**WELWYN HATFIELD BOROUGH COUNCIL
EXECUTIVE DIRECTOR - PLANNING, PUBLIC PROTECTION AND GOVERNANCE**

DELEGATED APPLICATION

Application No: 6/2017/2667/FULL
Location: 58 Plough Hill Cuffley Potters Bar EN6 4DS
Proposal: Erection of a detached 4-bedroom house following demolition of existing
Officer: Mr David Elmore

Recommendation: Refused

Rev	Detail	Date
A	Elevation, windows and internal layout	Nov 2017
Location		
58 Plough Hill		
Cuffley EN6 4DS		
Scale	Date	
As shown	Nov 2017	
Drq no		
DB / C / 205

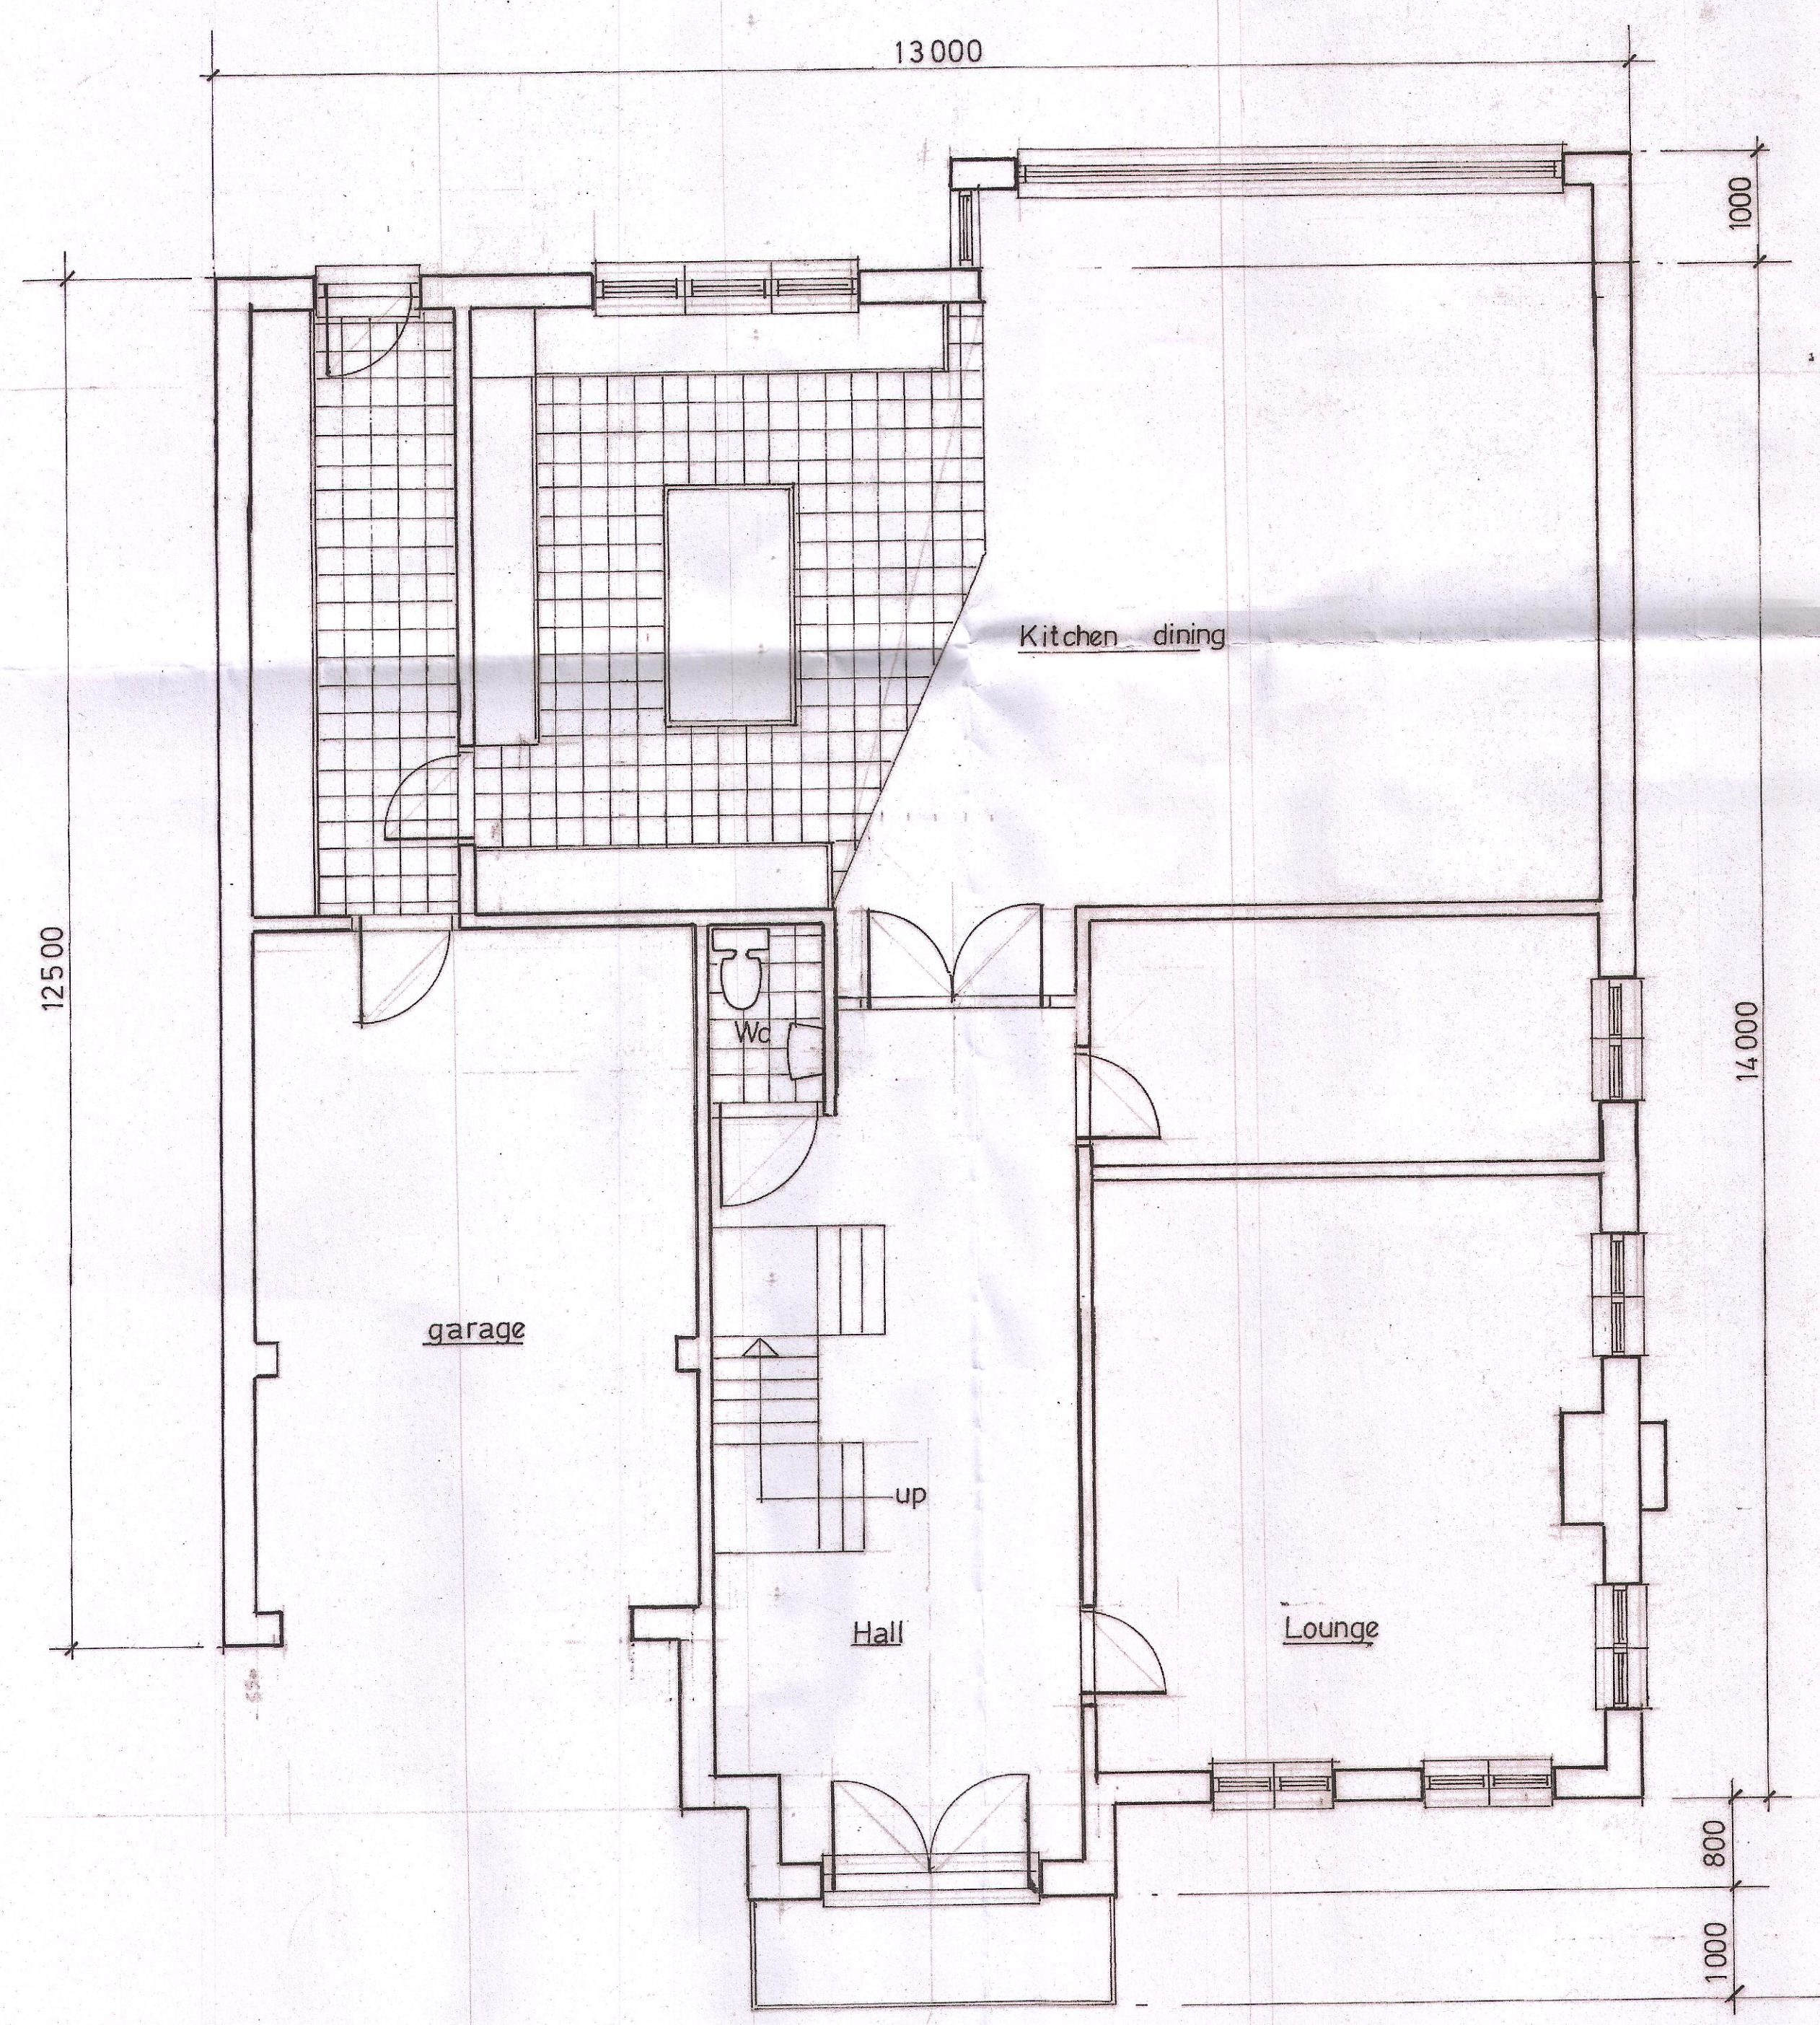
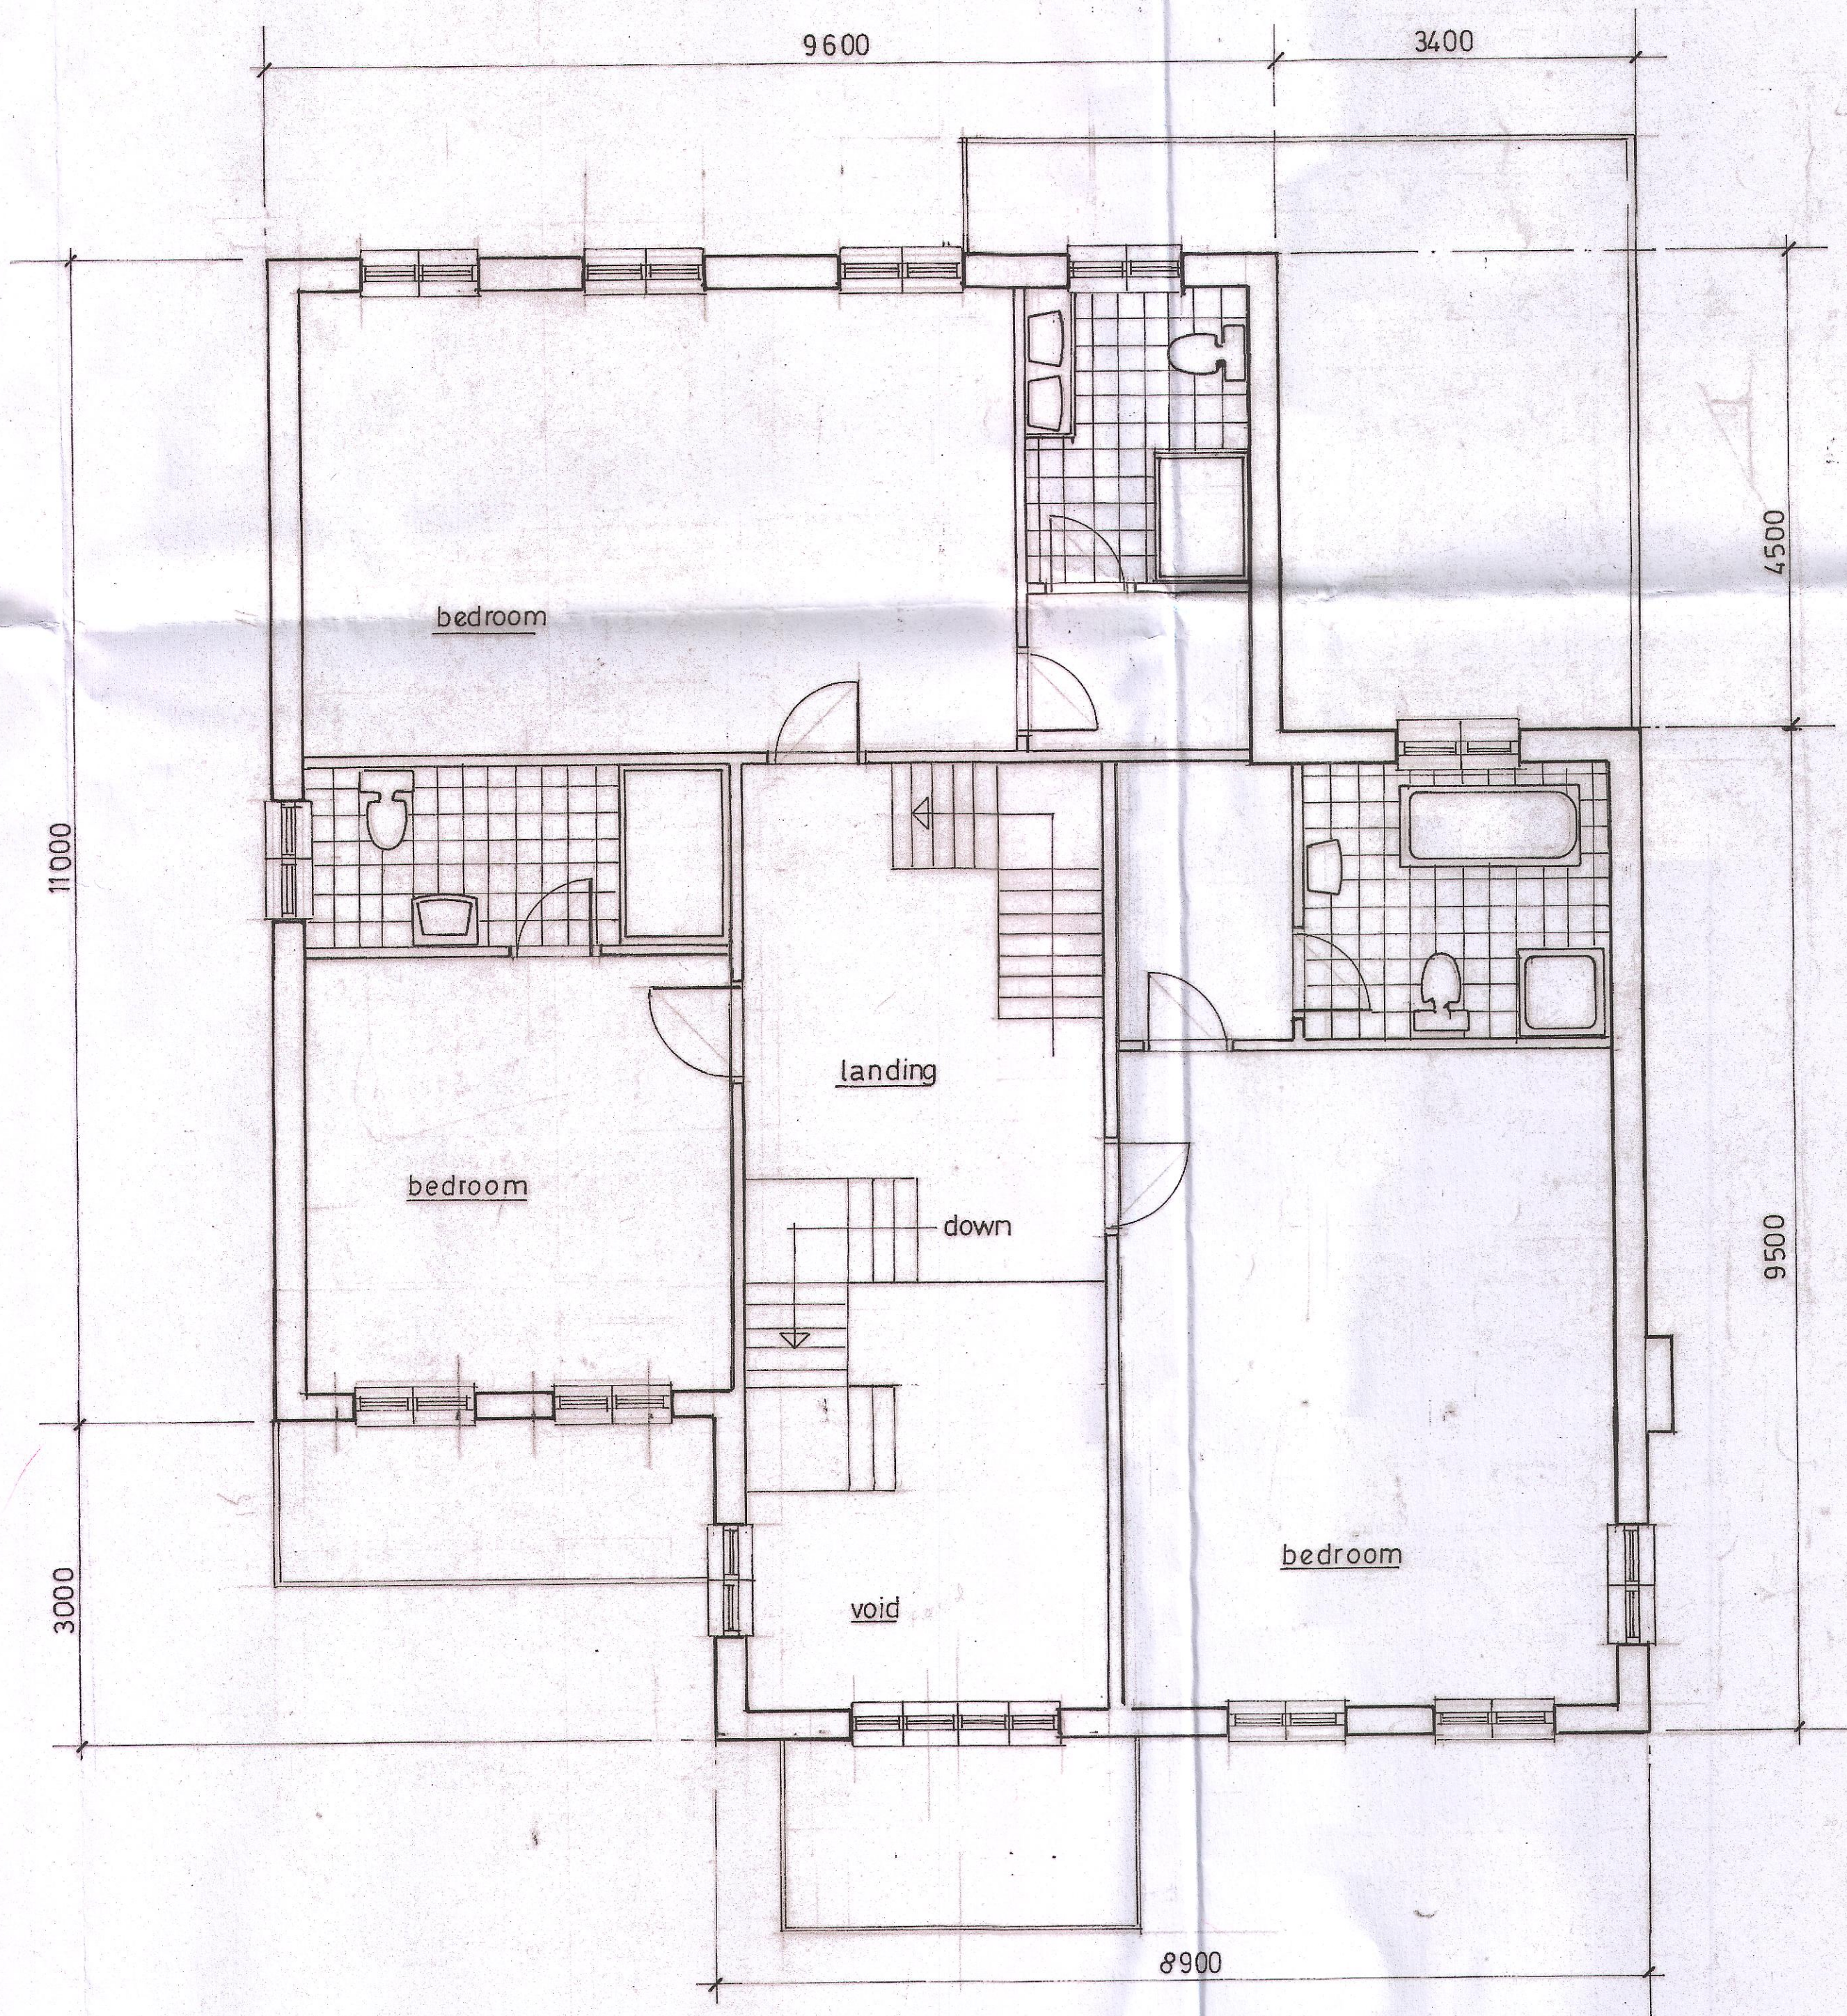
Impact on neighbours	<p>The main properties which may be affected by the proposal are the two immediate neighbouring properties, numbers 56 Plough Hill and 2 Hill Rise. All other nearby properties are considered to be sufficiently removed from the application site so as to remain unaffected by the proposal.</p> <p><u>56 Plough Hill</u></p> <p>This property is located to the immediate north-west of the application site and has been extend to its rear through a double storey side and single storey rear extension.</p> <p>The flank elevation of the proposed dwelling is staggered and as a result is set-in from the shared boundary by between 1.7m-4.7m. These set in distances, considered together with the height of the dwelling (lower than that approved under ref: 6/2017/0618/FULL) and carefully considered staggered formation, ensures that the proposed dwelling would not be unduly dominant or result in any adverse loss of light from this neighbouring property.</p> <p>In terms of privacy, 2no first floor flank windows (both serving separate bedrooms) and 3no roof-lights (serving a bedroom and bathroom) would face the flank and rear garden of No. 56. In the interest of maintaining levels of privacy, these windows can be conditioned to be glazed with obscure glass and have a restricted level of opening.</p> <p><u>2 Hill Rise</u></p> <p>This property is located to the immediate south-east of the application site. The flank wall of the proposed dwelling would be set-in at least 1m from the shared boundary (similar to the existing dwelling) and staggered to the front in order to reduce its effect on the nearest front and side windows of No. 2. The flank wall of No. 2 is set-in a further 4m from the shared boundary.</p> <p>Whilst the proposed dwelling would be 0.3m greater in height than the existing dwelling, having regard to the set-in distances of the proposal from the shared boundary and flank of No. 2, together with its positioning relative to No. 2 and overall scale, it is not considered that the proposal would be unduly dominant or result in any adverse loss of light from this neighbouring property.</p> <p>A first floor side window (serving bathroom) and 4no roof-lights (serving bedrooms and an en-suite) would face predominately the flank of this property, and to a lesser extent, its rear garden. In the interest of maintaining levels of privacy, these windows can be conditioned to be glazed with obscure glass and have a restricted level of opening.</p>
